Engineers Comments Regarding Surface Water Drainage

Application Reference:	BN/15/26/HH	Reviewer Reference:	ADC/KW
Planning Officer:	Rhiannon Lloyd	Date of Review:	25/02/2026
Site Name:	15 Elm Grove, Barnham, PO22 0HJ		
Application Description:	Demolition of existing single storey side area. Construction of two storey side extension, single storey rear extension and single storey front porch extension. Fitting of external insulation with render finish. Alterations to existing fenestration.		
Assessment Number:	1 of 1

DRAWING TITLE
 PROPOSED SITE PLAN
 (NEW SCHEME)

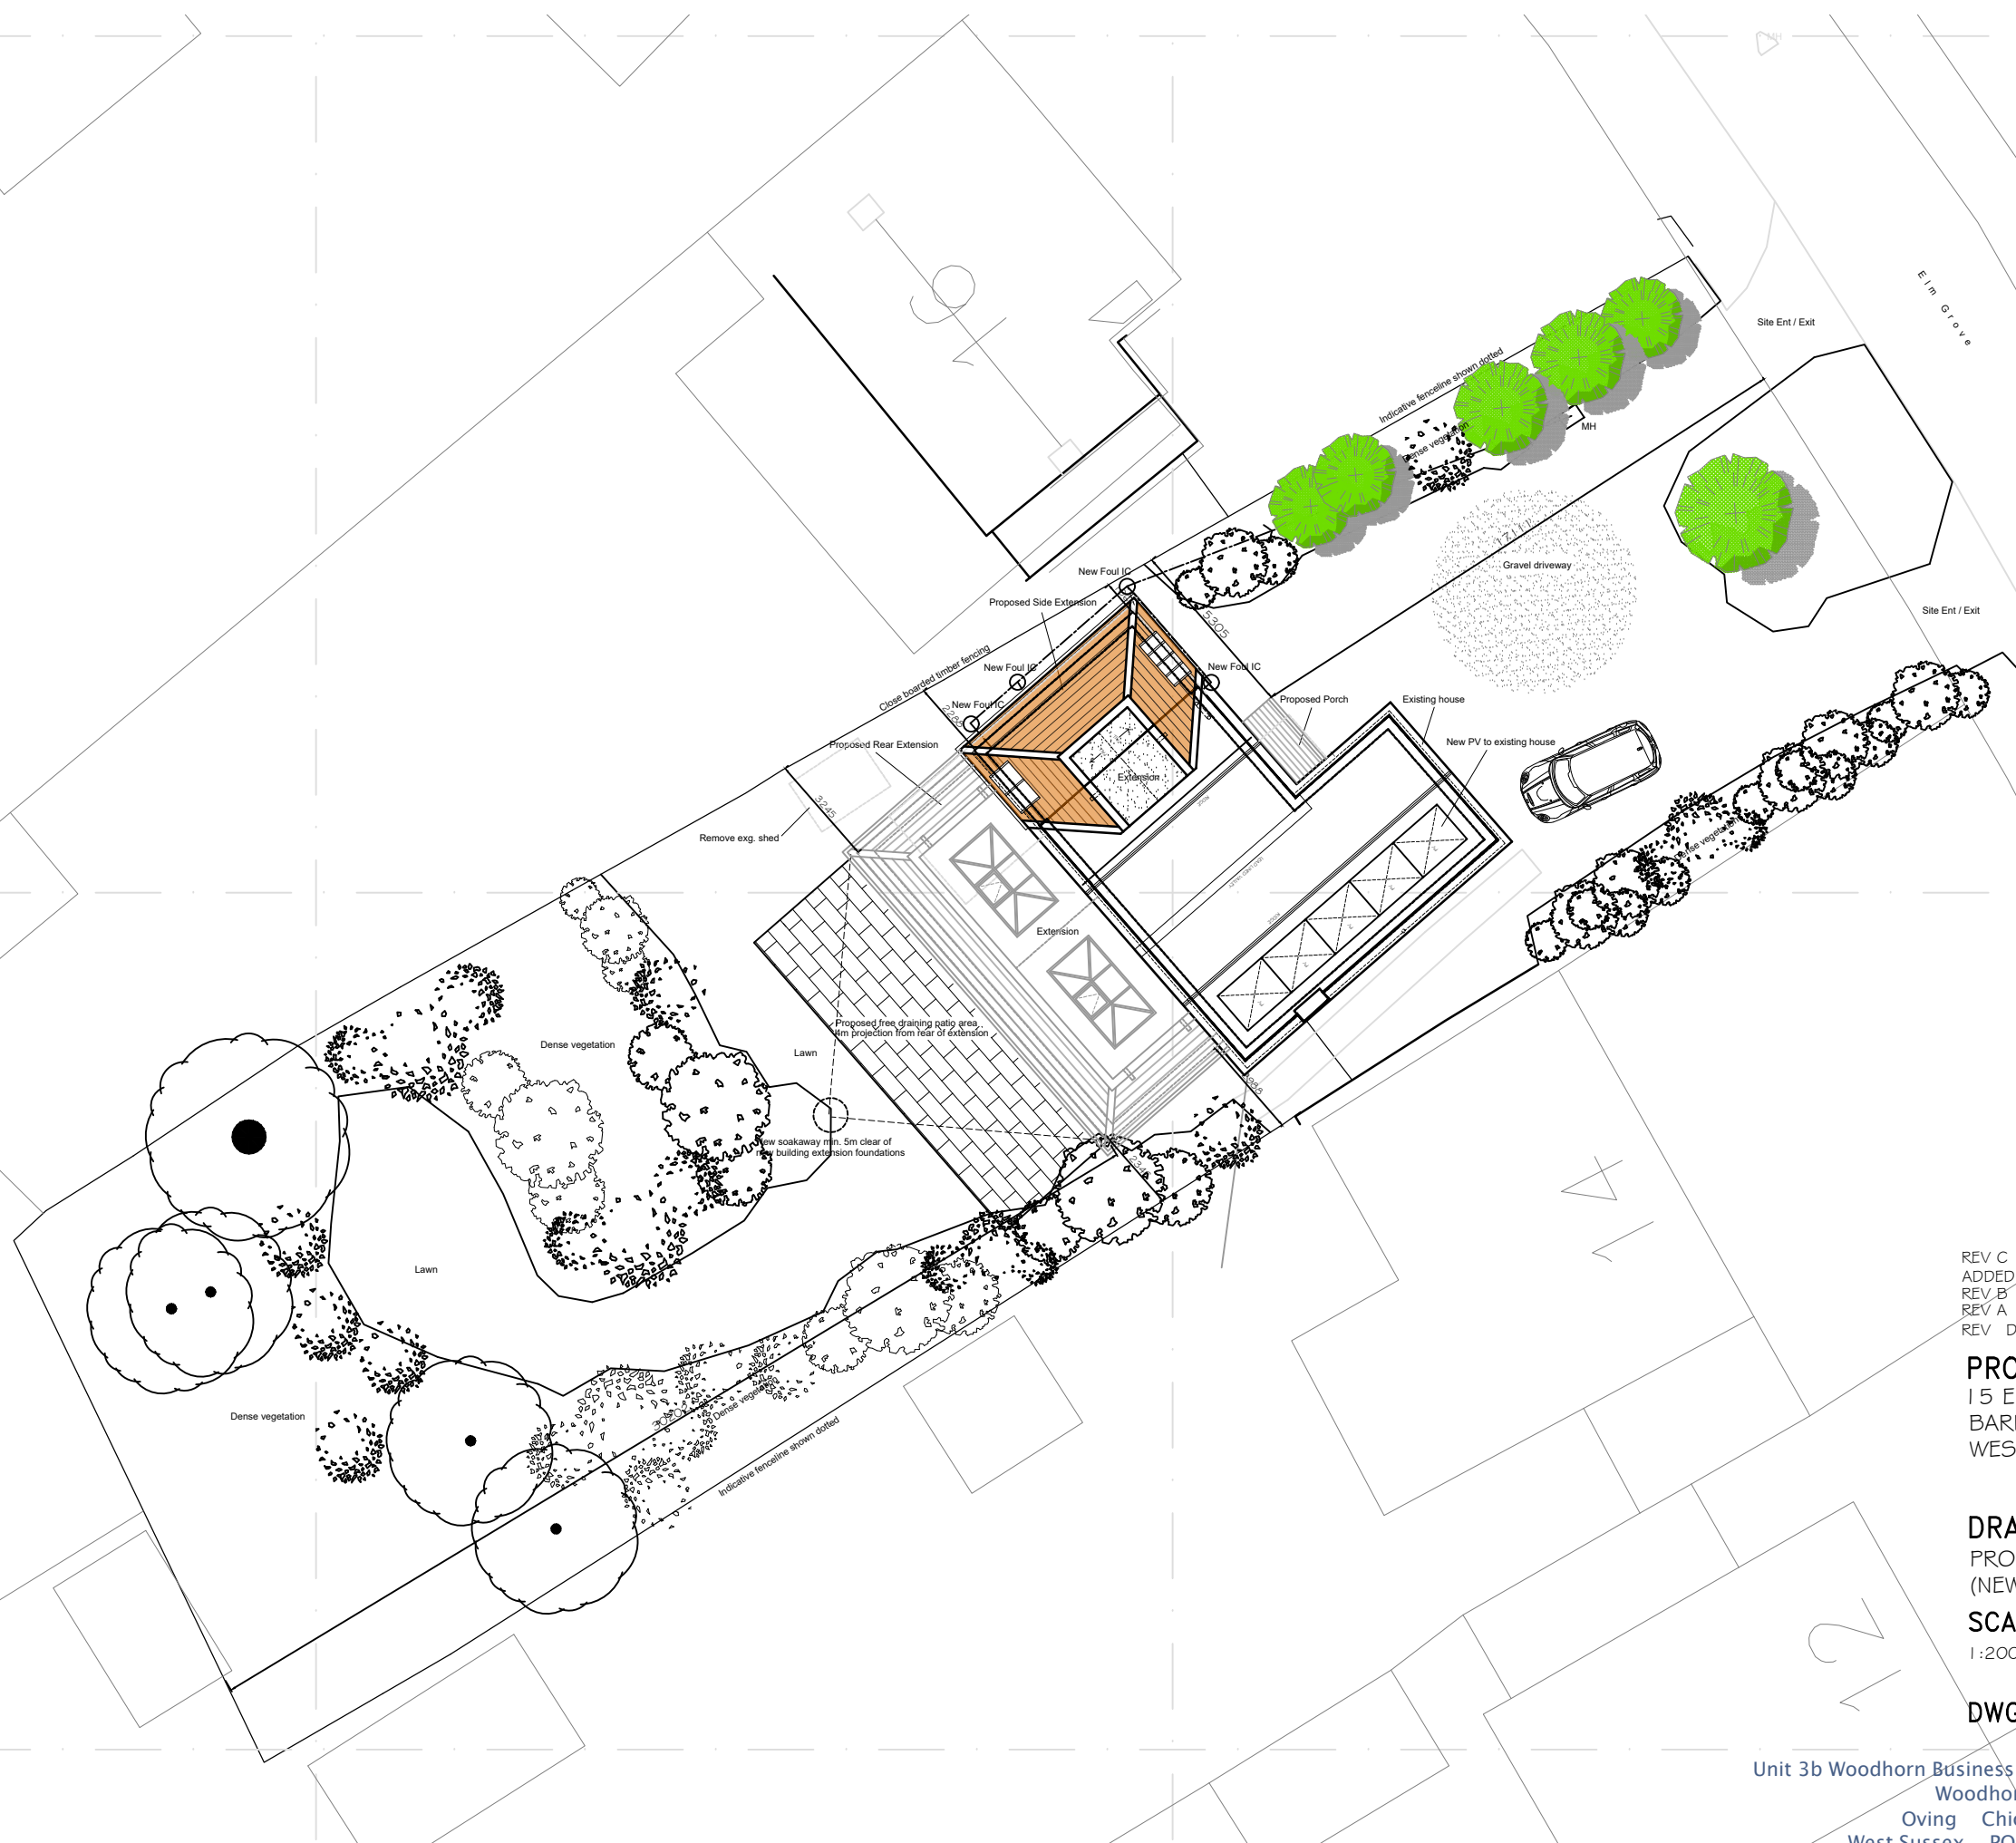
1.1. It is proposed to infiltrate to soakaways to the front and rear of the property. A permeable driveway is also proposed. Whilst this is positively viewed, and accords with Standard 1 of the NSfS, insufficient evidence has been provided at this time to prove viability. It is the responsibility of the applicant or their drainage designer to provide this evidence. For this reason, **we object** to the proposal, as the submission of such evidence may affect the scale and layout of the development.

1.2. To support an infiltration-based design, winter groundwater monitoring must be undertaken to confirm that a minimum of one metre of unsaturated ground can be maintained between the base of the soakaway or infiltration structure and the peak groundwater level. Ground conditions and infiltration potential in Barnham are highly variable. While infiltration may be feasible in some areas, others experience high groundwater levels or poor infiltration rates that render it unviable. This must be robustly demonstrated by the applicant.

1.5. There is a private surface water sewer located to the east of the property, within the highway. No information regarding this option has been submitted. If infiltration is not viable, the applicant would need to investigate the possibility of connecting surface water to the sewer at the front of the site including hydraulic capacity checks etc.
